Department of Transportation

January 31, 2024

RE: RVP231 - Lazy Y Rocking J RV Park Rezone

The submittals for Lazy Y Rocking J Park received on 1/9/2024 have been reviewed by CDOT Access Management. Our comments follow:

# LAZY Y & ROCKIN J SITE SITE ENTRY AUTOTURN EXHIBIT

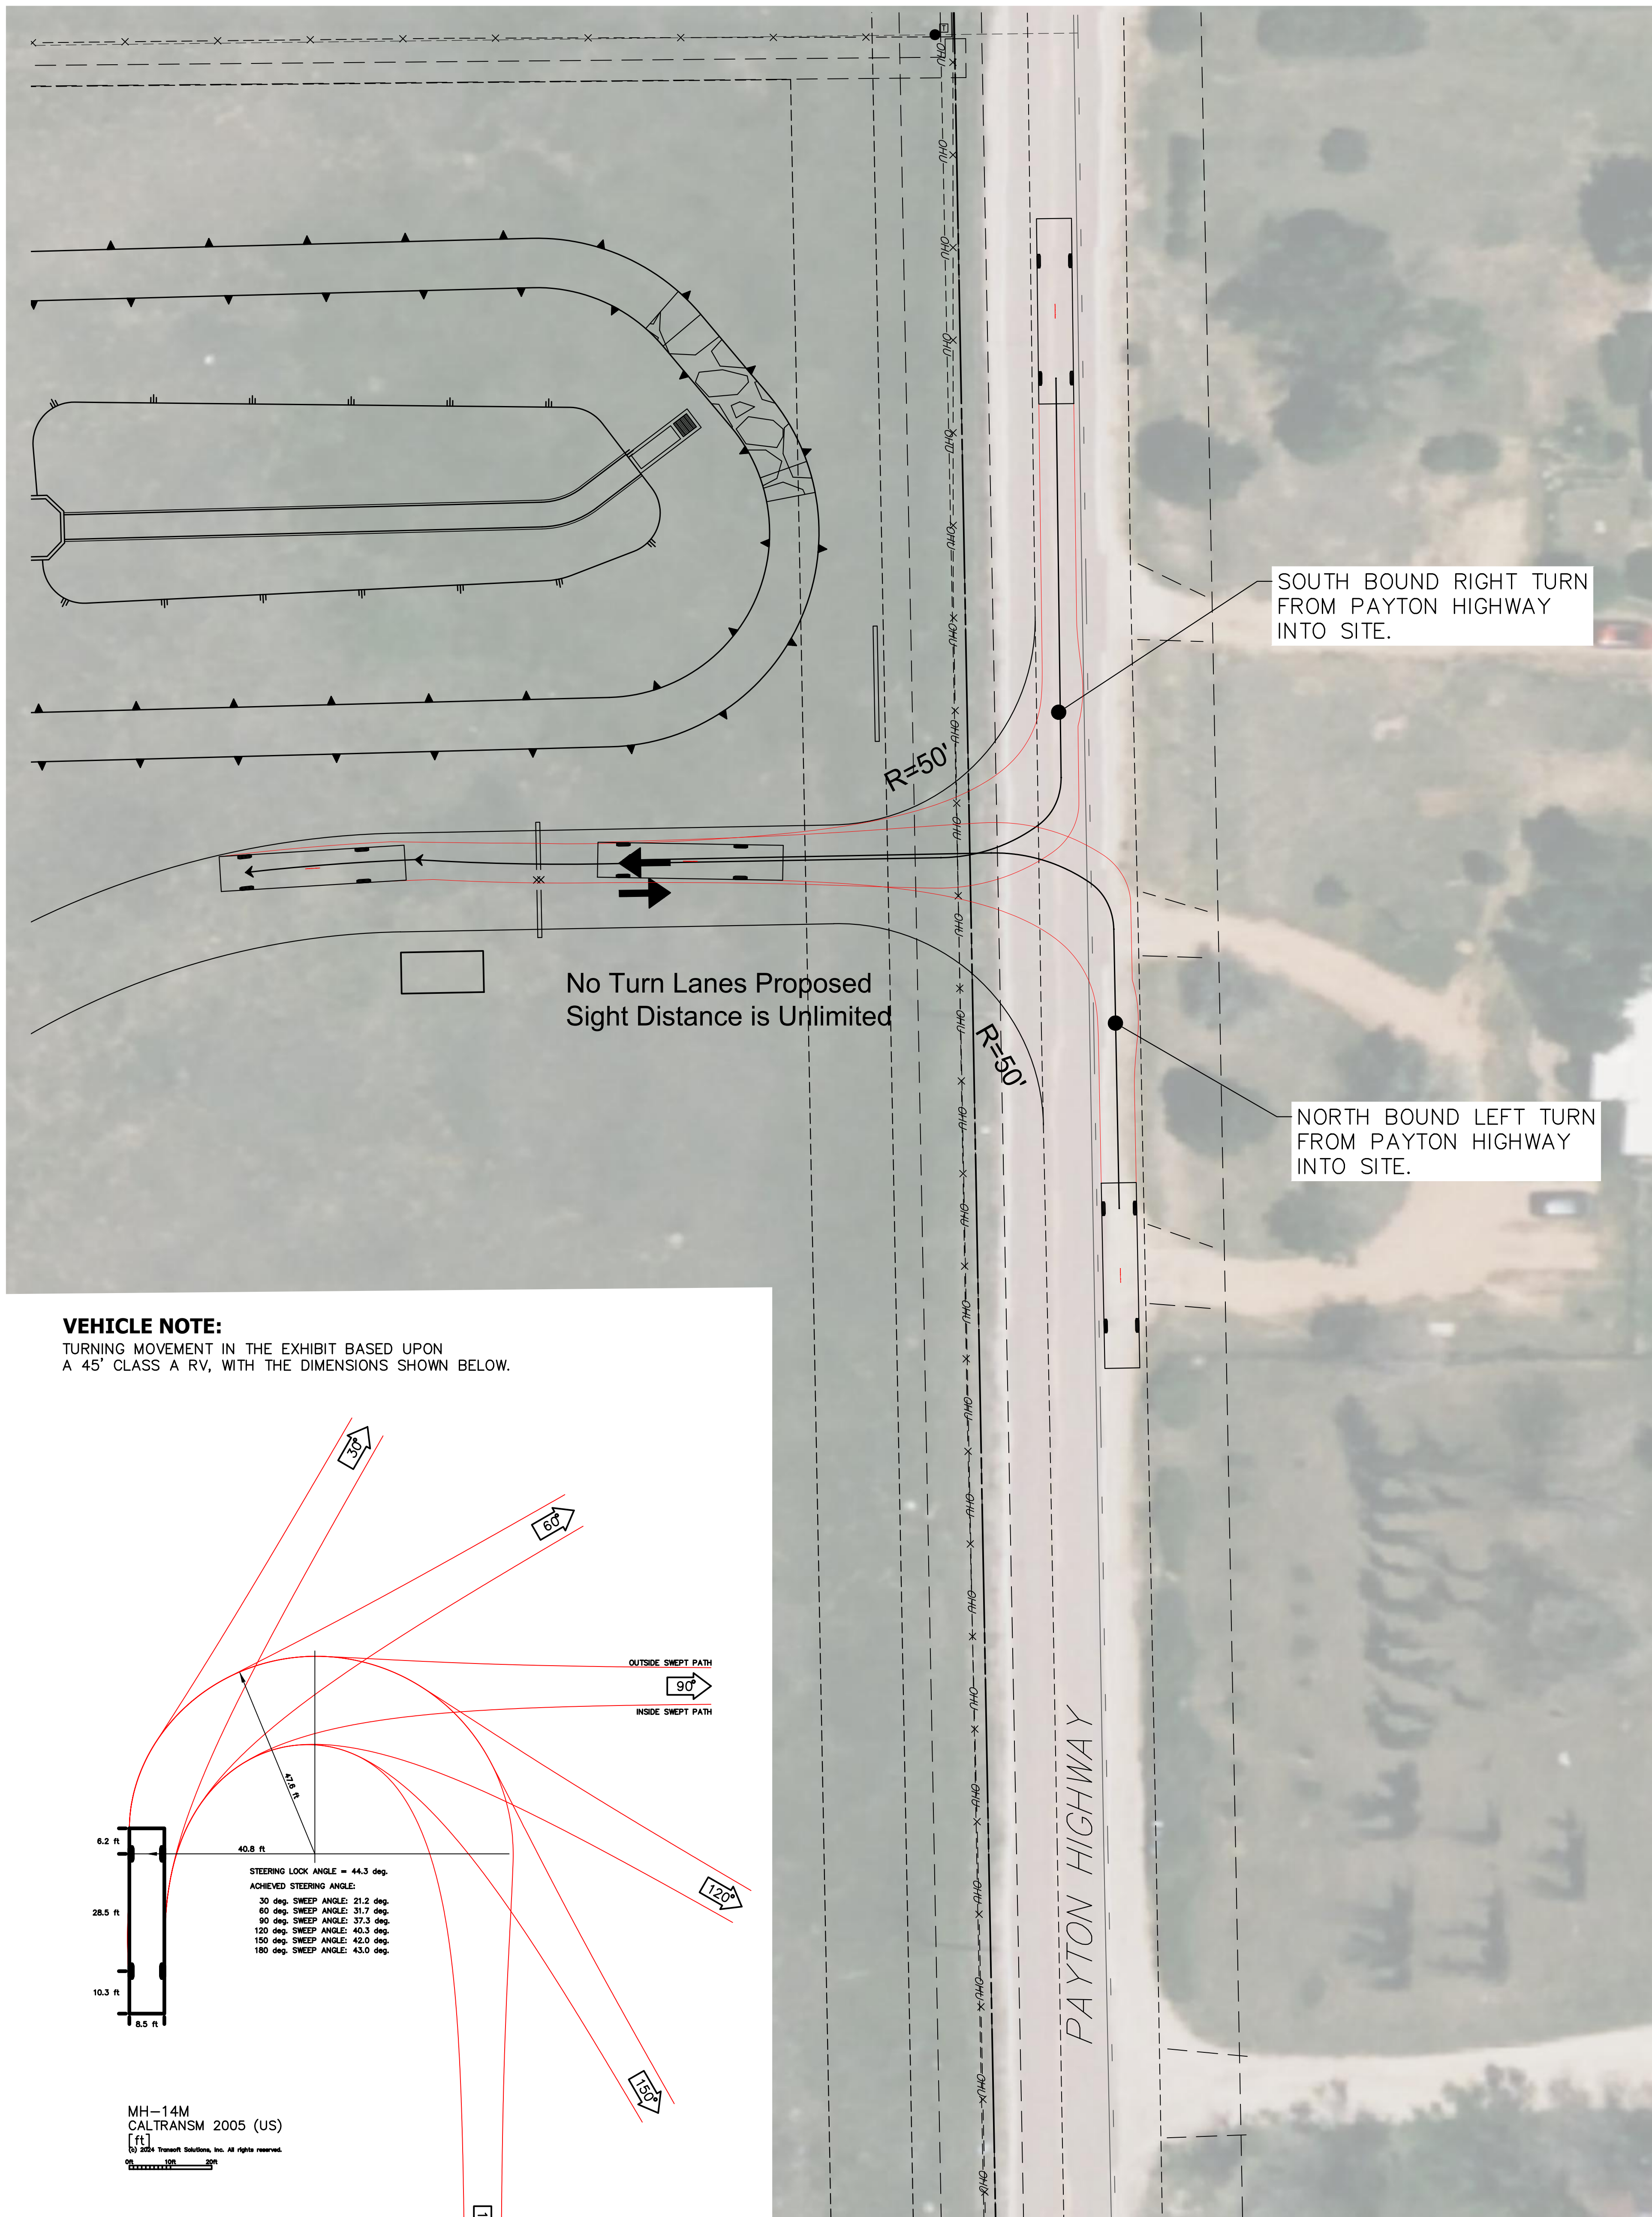
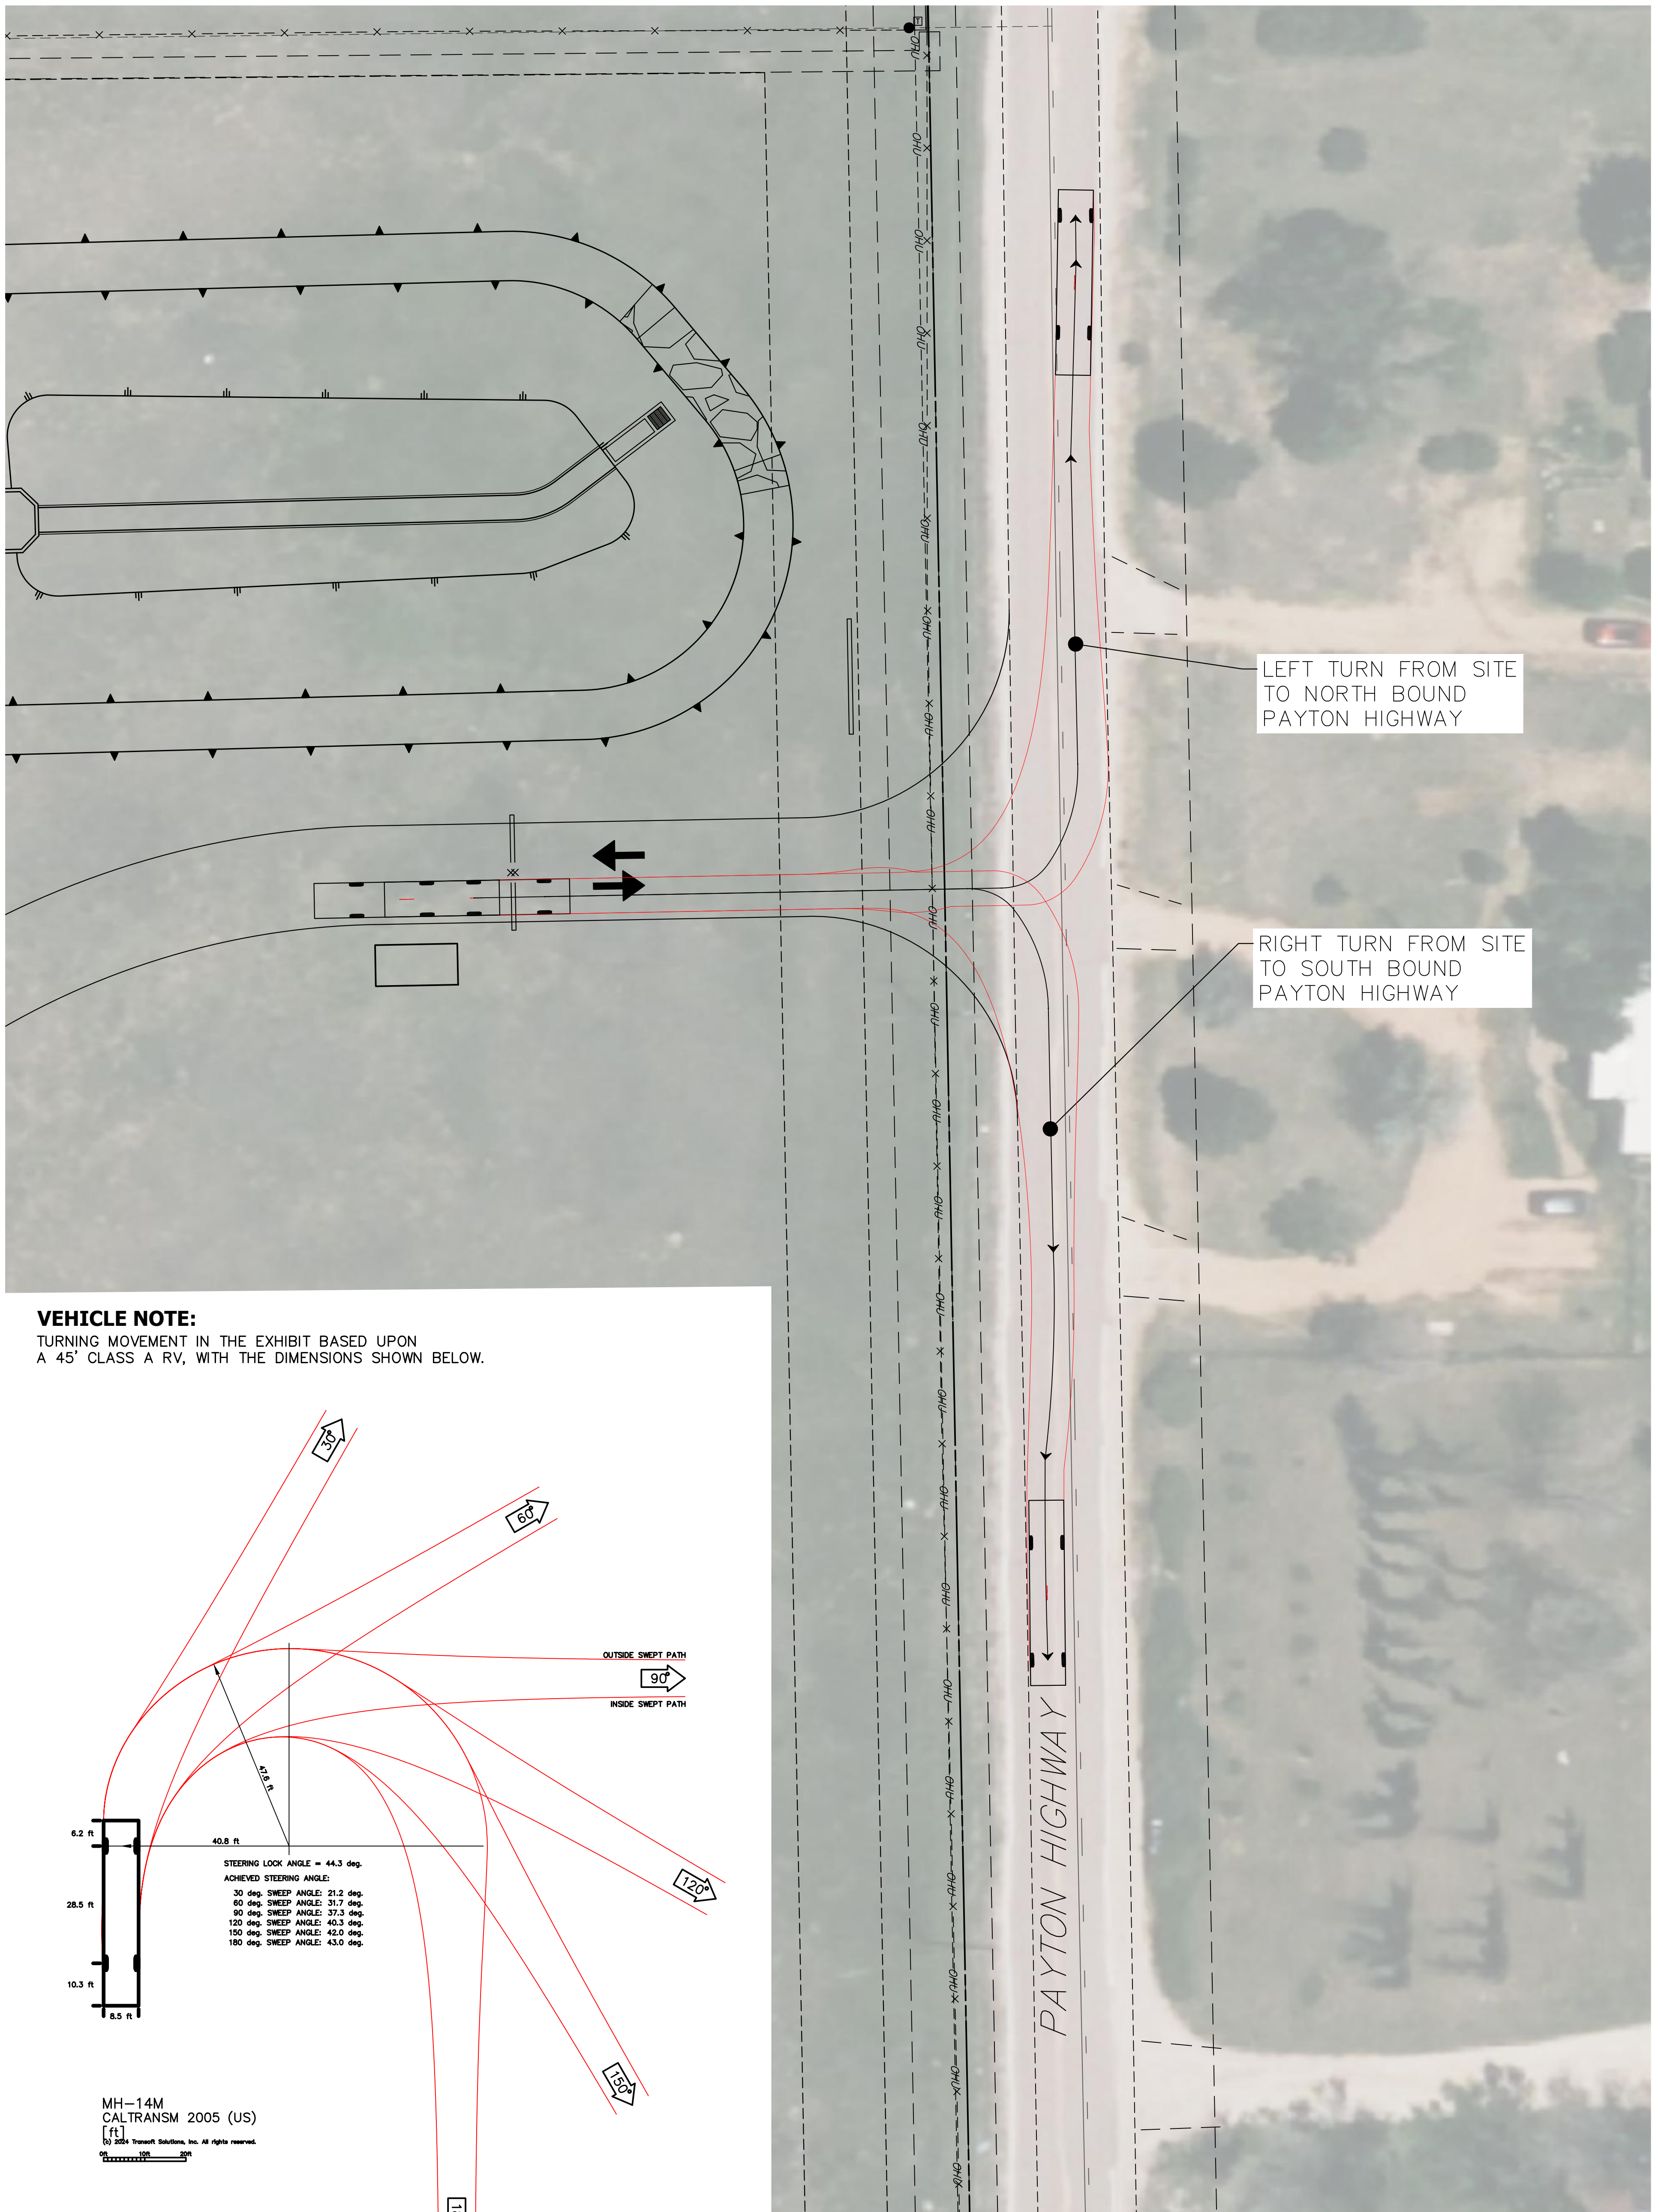
- CDOT Requests that the development provide traffic information and intersection impacts for USHwy 24G and Peyton Hwy. Please revise the transportation memo and resubmit.
- CDOT does not anticipate that the development would likely interfere or impact CDOT infrastructure or interchange, a CDOT Access Permit will not be required at this time.
- CDOT would like to review any future traffic, drainage and improvement related submittals for the development including: Traffic Studies, Trip Generation, Drainage Reports or Letters.
